From: Jonathan Best <Jonathan.Best@arun.gov.uk>
Sent: 12 June 2026 11:43
To: Planning.Responses <Planning.Responses@arun.gov.uk>
Cc: Simon Davis <Simon.Davis@arun.gov.uk>; Neil Crowther <Neil.Crowther@arun.gov.uk>
Subject: A/44/26/PL additional ecology comments

Former Shrublands Nursery Roundstone Nursery Angmering BN13 4AT.

I have reviewed the amendment with regards to the bat and bird boxes. These proposals are acceptable.

Client's Name	Drawing Title		
Sigma Homes	Proposed Elevations- Plots 11, 12, 26, 27		
Job No	Drawn	Checked	Date
6855	JT	AK	22.12.20
Job Title	Status	Rev	Rev
The Former Shrubland Nursery, Roundstone Lane, Angmering		PL-125	P2

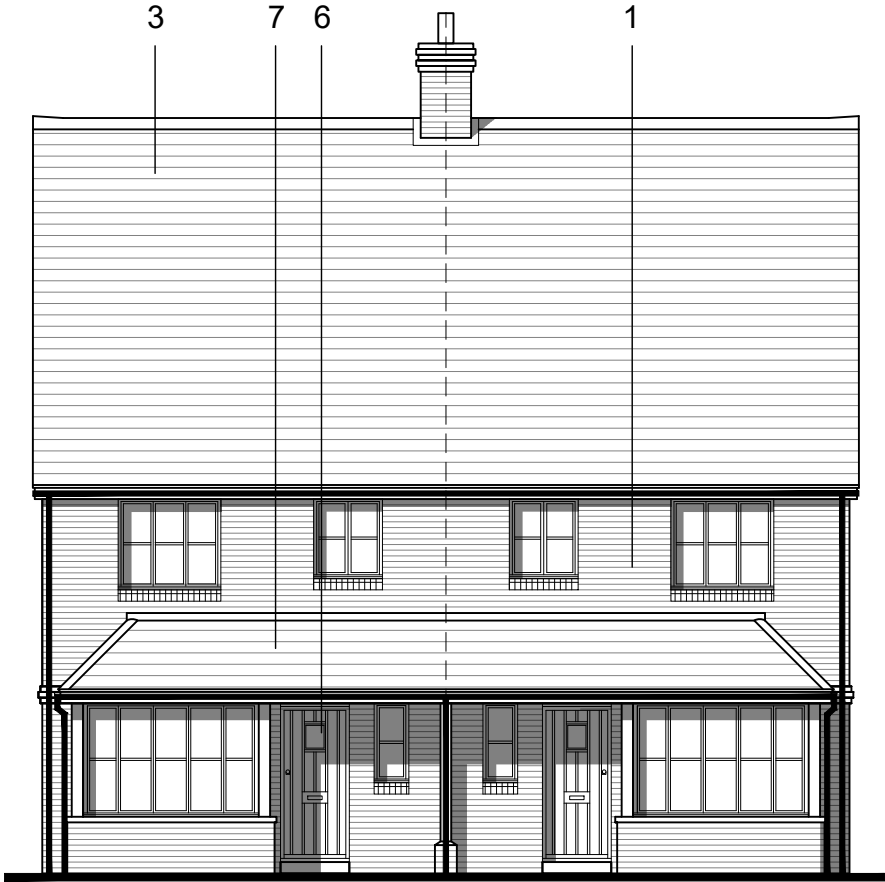
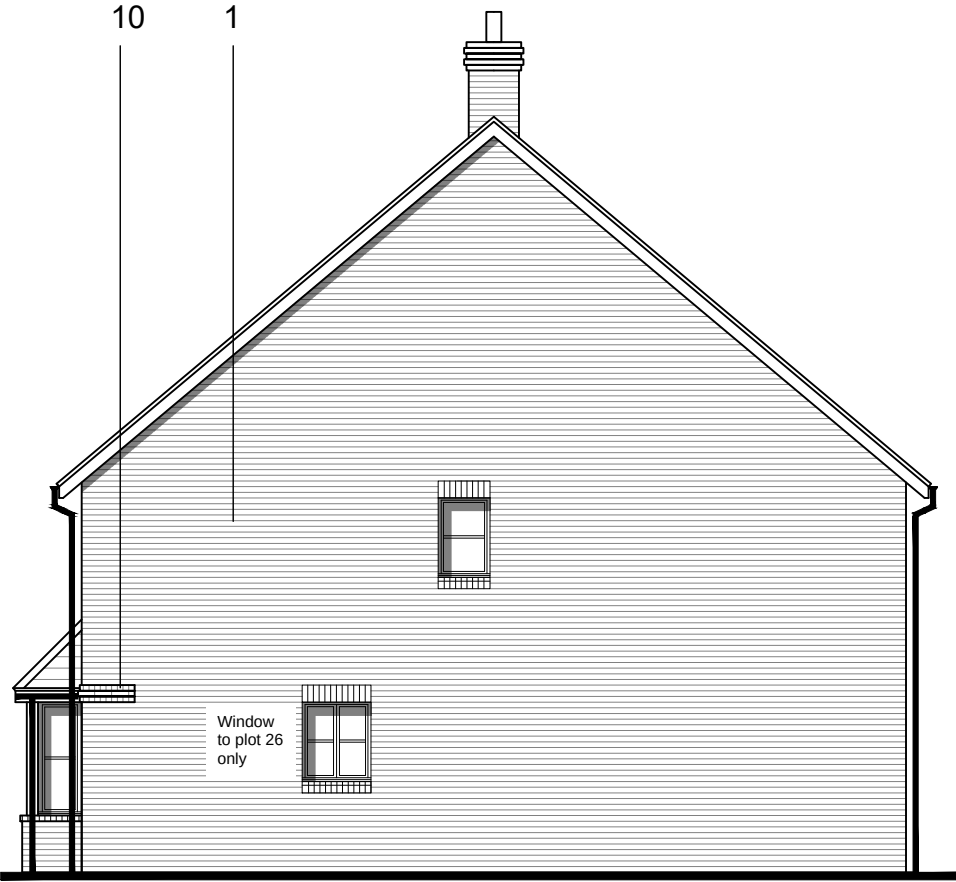
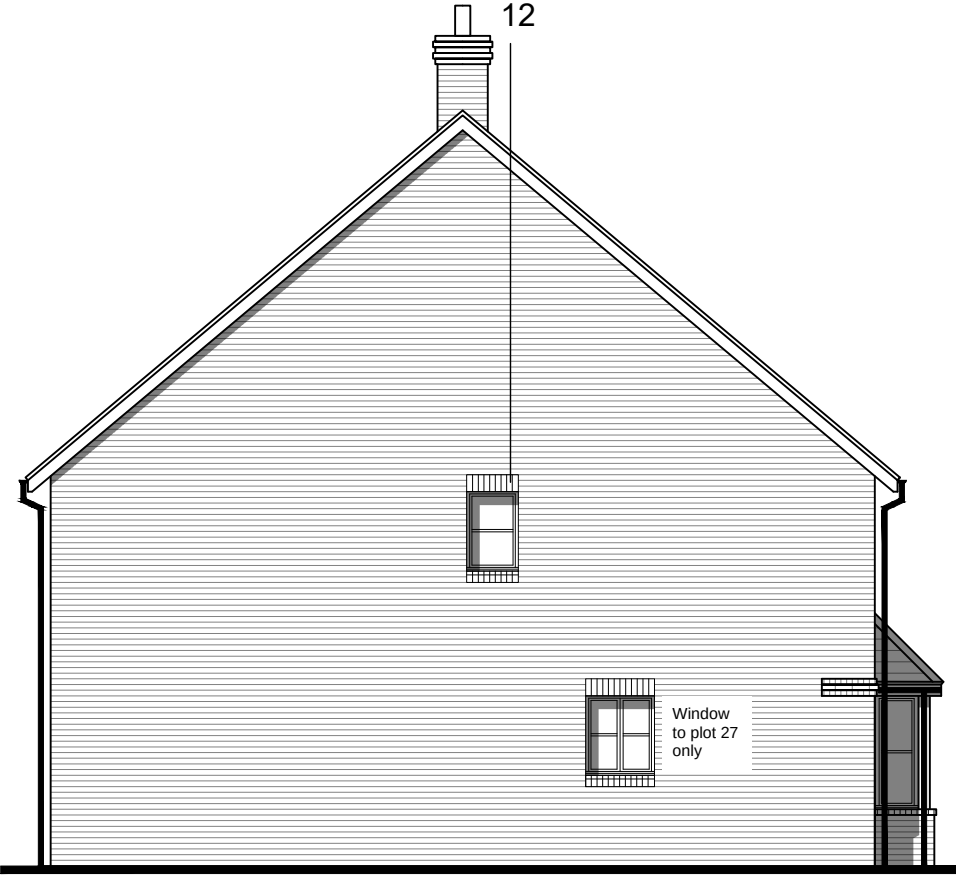
It is advised to relocate bird boxes on P-25 and P-27 to face east or north, as they are west facing and may overheat.
